Western Sydney University
c/- Murray Donaldson
Director
Urbis
Level 8, 123 Pitt Street
Sydney NSW 2000

17/12/2019

**Western Sydney University Bankstown City Campus (SSD-9831)
Response to Submissions**

Figure 16 | Areas of Paul Keating Park that would retain four or more hours of solar access at mid-winter (Base source: SRtS)

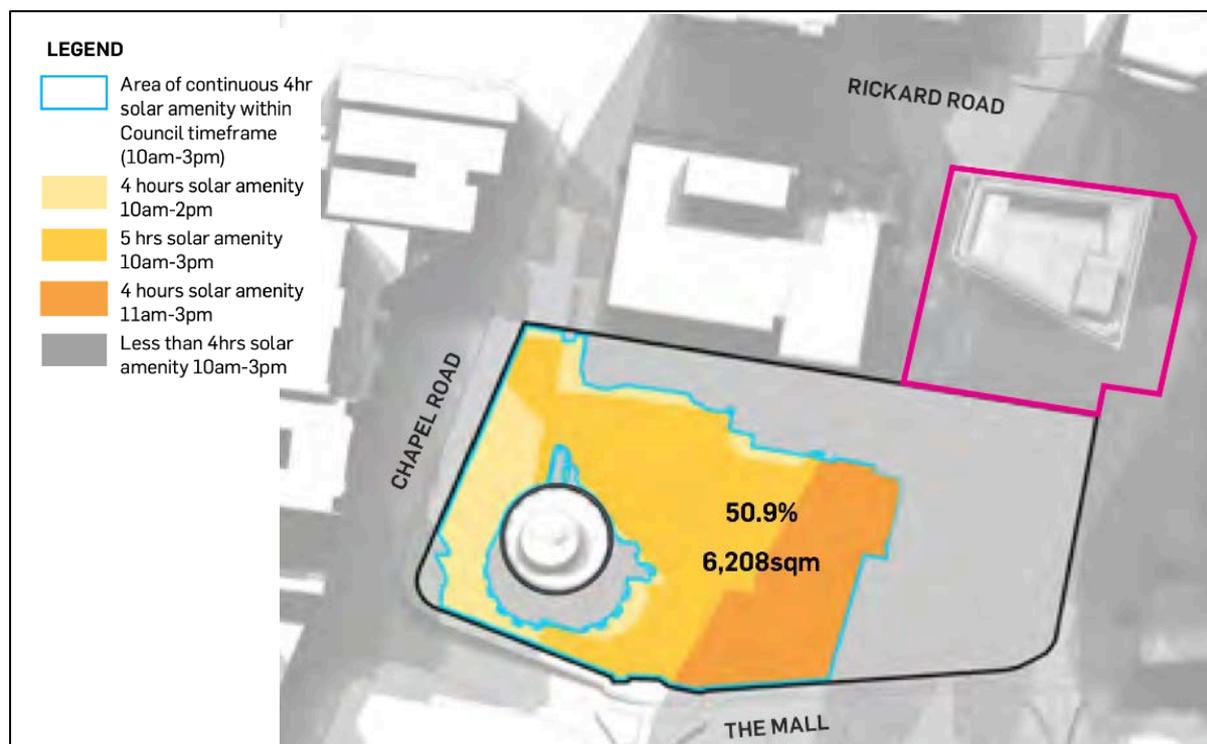
- The Applicant's acknowledgment and consideration of the potential overshadowing impacts to Paul Keating Park in the design of the proposed built form has not provided any substantial public benefits or reduction in impacts to the open space.

The largely hardscaped public domain space surrounding the local heritage Council Chambers has been included in the calculations of 'open space' that would be impacted. This assessment presented does not properly consider the impact of the proposal on the actual RE1 Public Recreation zoned land.

The Department therefore requires the assessment of the proposal's overshadowing impact on Paul Keating Park be revised to consider the land zoned RE1 Public Recreation under BLEP 2015 only. Any adverse impacts identified must be appropriately minimised to ensure the ongoing amenity and enjoyment of this public recreation area.

It is noted that the planning proposal includes a clause requiring a minimum of four hours of continuous solar access to a consolidated area of Paul Keating Park during mid-winter. This requirement should be addressed in the response to submissions, including whether is it a pre-requirement for determination or otherwise.

Figure 26 | Council's current plan for stormwater upgrade works, including box culvert and associated connections, under North Terrace (Source: Council)

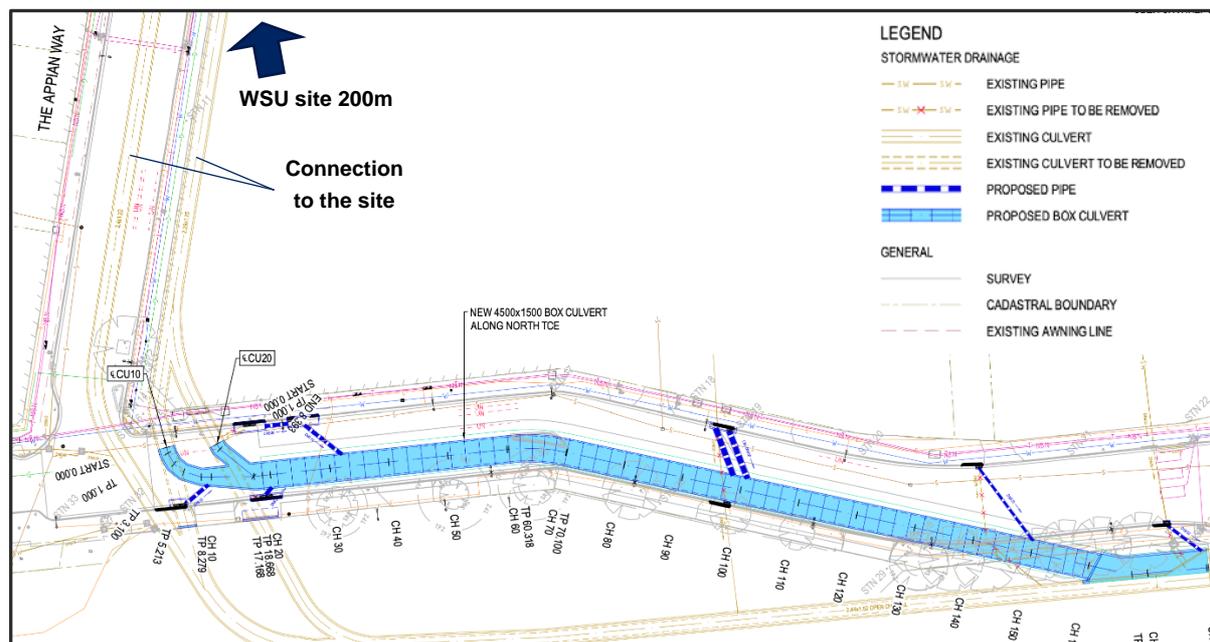
- The proposal seeks to contribute to the revitalisation of the locality through the establishment of active street frontages at the ground plane interface, particularly along The Appin Way.

Details must be submitted demonstrating that necessary improvements will be made to support the establishment of such an area and to mitigate against documented hazardous flooding conditions that would only be exacerbated by the proposed siting of the development.

Figure 27 | Extract from Public Domain Plan showing responsibility for delivery of works by location and potential drop-off zone locations (Base source: SRTS)

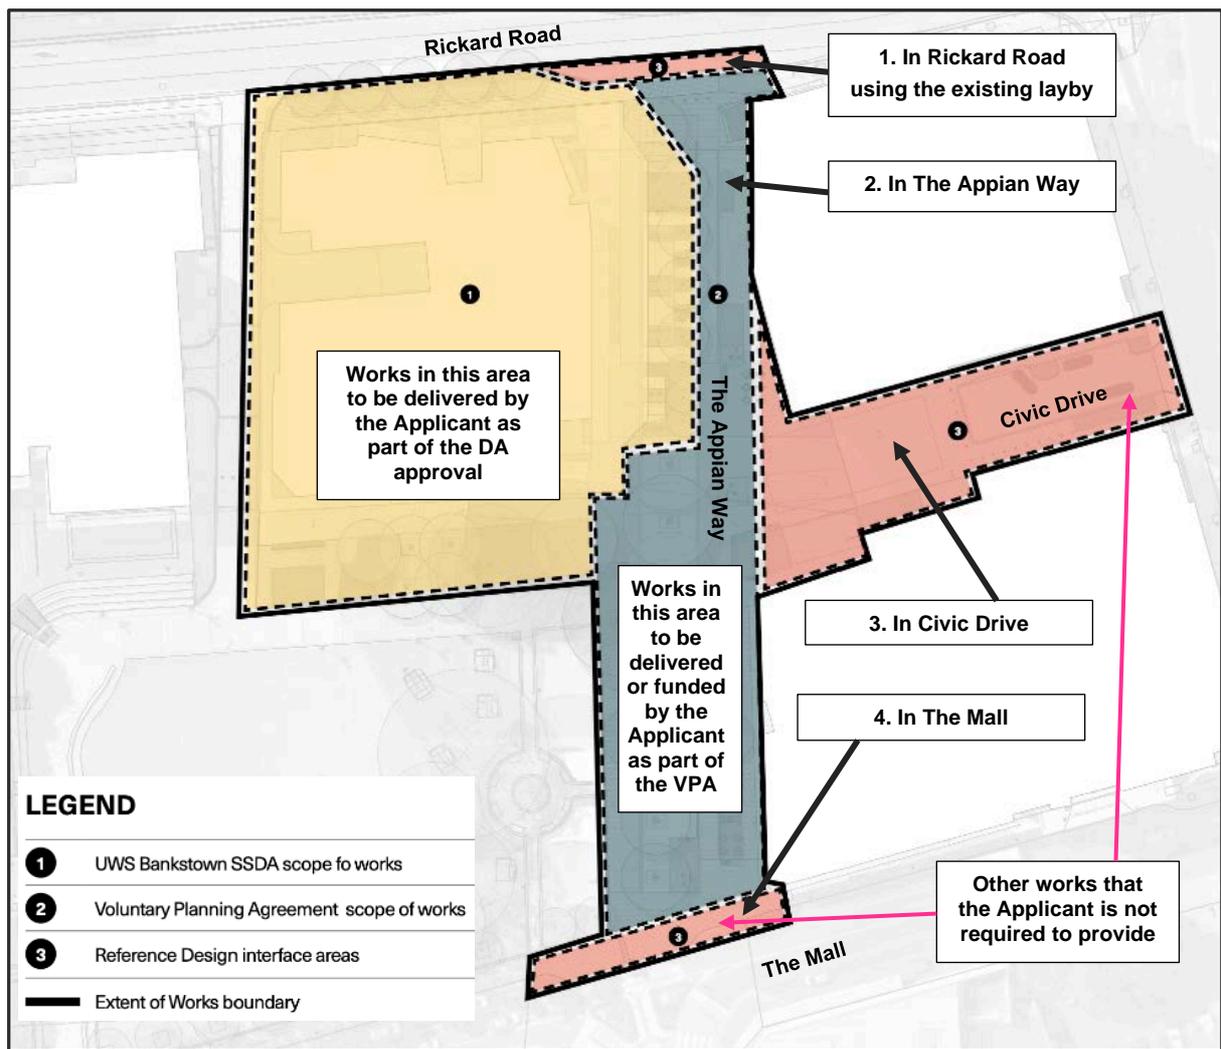
- To ensure the impacts of urban heat island effect are mitigated and the biodiversity values of the site are improved, the submitted landscape design must be updated to address the comments provided by the Environment, Energy and Science Division of the Department.
- The landscape plan must include details of the proposed pavement design and any threshold treatments for the proposed pick-up/drop-off facility on the eastern side of Appian Way.

- The design of vehicle access arrangements must be reviewed to ensure that all medium ridged vehicle movements do not conflict with kerbs and pedestrian environments (i.e. The Appian Way and basement entry ramp).
- An assessment of the adequacy and operational performance of the proposed pick-up/drop-off facility is to be provided in supporting a transport mode shift away from private vehicle usage. This assessment must also consider the potential use of the facility from other surrounding land uses and the impact of this on its operation in conjunction with the proposed university use.
- Consideration is to be given to the provision of additional end-of-trip facilities for students to encourage more active travel modes, noting the close proximity of many students living within two to five kilometres of the site.
